City of Albuquerque Stormwater Construction Site Inspection Report

ESC File No.	K10E060	Project Name:	7200 Bluewater		
NPDES Id. No.	NMR1003UT	Location:	7200 Bluewater		
7/27/2021	Owner	Contractor			
Operator	M & B Investments Ltd. Co.	GA Brunacini Construction			
Contact name & title	Angelo Brunacini	Angelo Brunacini			
e-mail	abrunacini@brunacini.com	abrunacini@brunacini.com			
Contact Phone #	505-833-2928	505-833-2928			
COA Inspector	Doug Hughes	Start/End Time:	2pm		
Construction Phase:	Earthwork				
Type of Inspection:	Regular	Storm Event	Past Storm Event >0.25"	311/Complaint	Follow Up
Weather at time of inspection?		clear		Temperature: ~	90
Estimated date of last storm 0.25" or greater		7/31/2021

ENGINEER'S SEAL	7200 BLUEWATER RD ALBUQUERQUE, NM	DRAWN BY pm
	EROSION CONTROL PLAN	DATE 7-20-21
		DRAWING 2020056-SWPPP
	TIERRA WEST, LLC 5571 MIDWAY PARK PL NE ALBUQUERQUE, NEW MEXICO 87109 (505) 858-3100 www.tierrawestllc.com	SHEET # SW-1
RONALD R. BOHANNAN P.E. #7868		JOB # 2020056

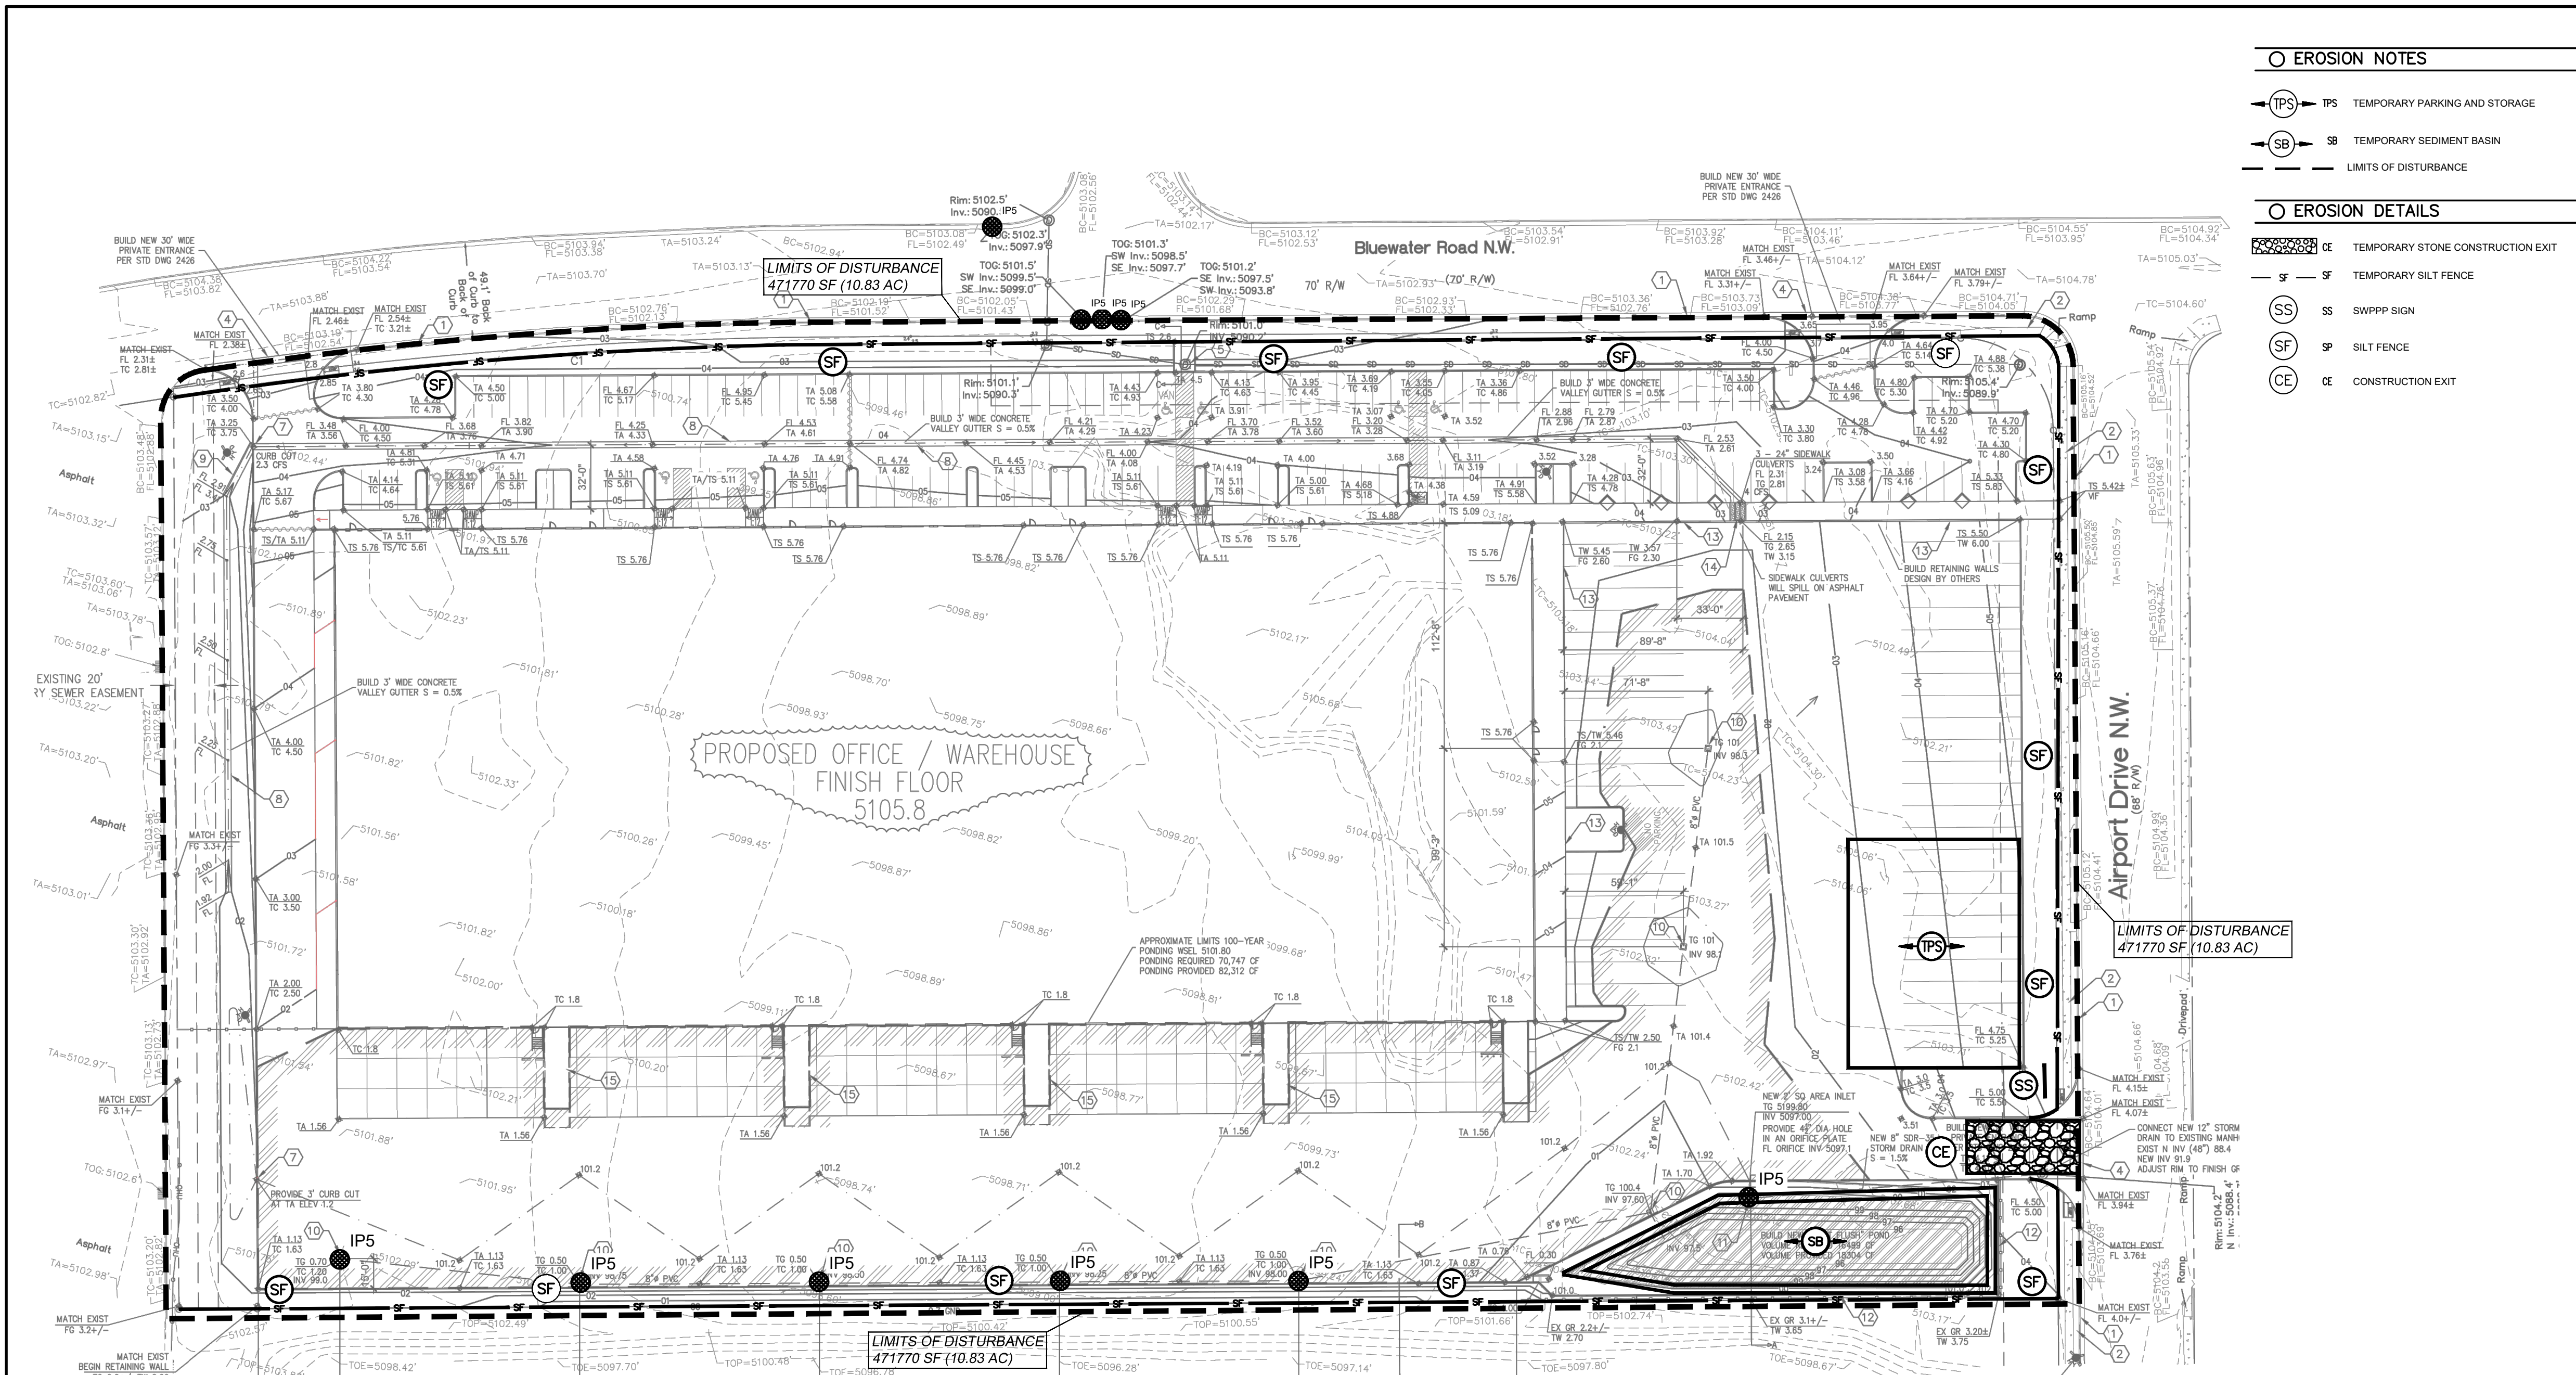
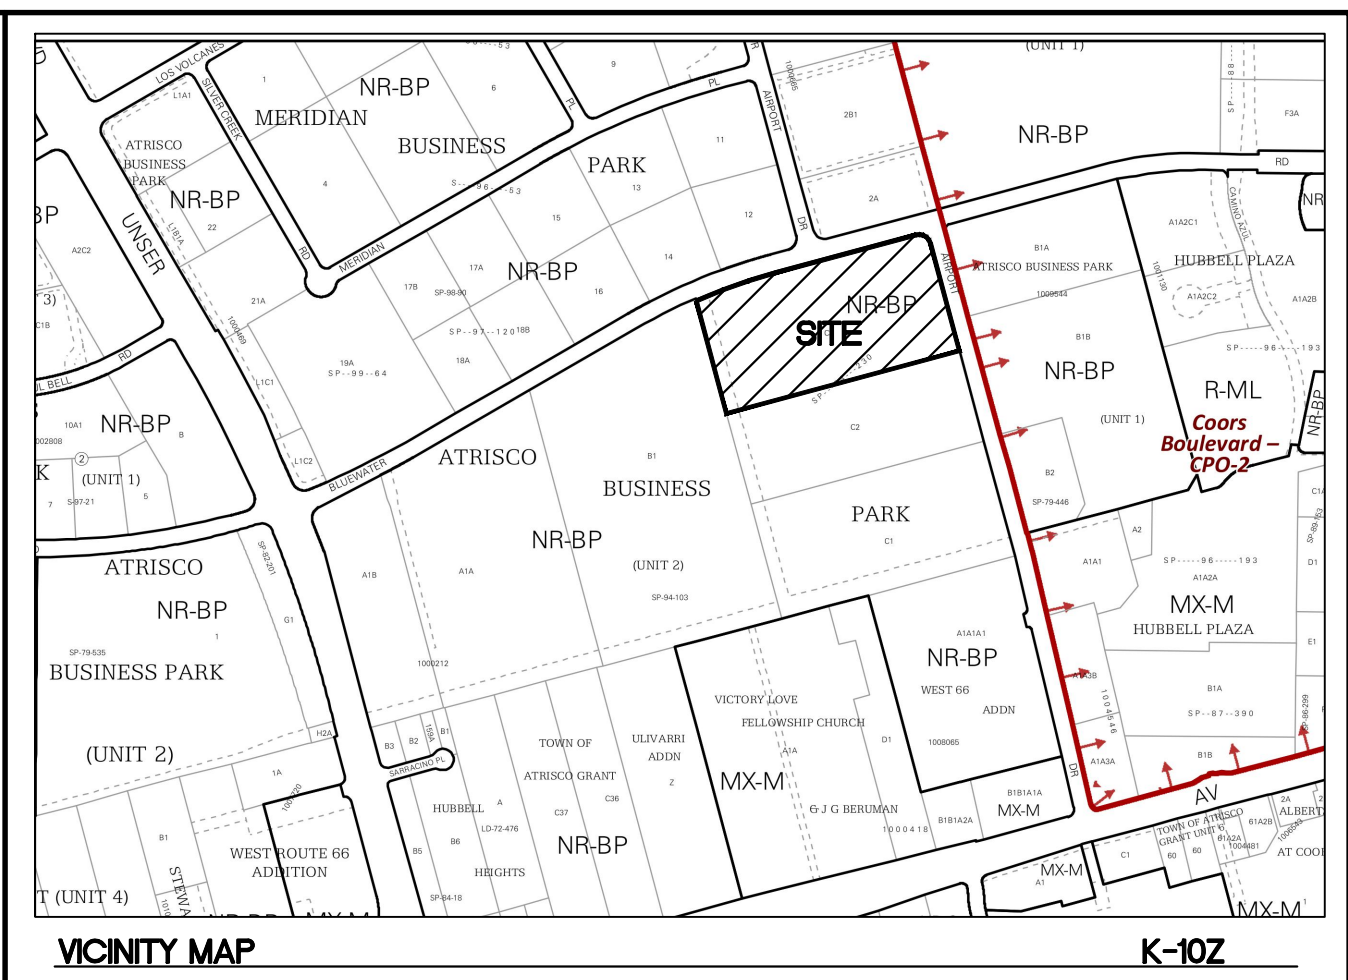
Item Number	Deficiency/ Corrective Action				
1	Permit coverage was not properly posted, ID # missing from sign, phone numbers on sign don't have SWPPP, Location of SWPPP not identified.				
2	SWPPP was not onsite though it eventually got there. It must be available onsite, and up-to-date. Map missing, Owner/Operator NOI and certification missing.				
3	Trackout and sediment in the street at entrance and near inlets. Water truck started washing street sediment into curb and maybe into inlets. Pickup and remove sediment from street and sidewalk daily. Never wash it into inlets!				
4	10' hole in north silt fence needs repair				
5
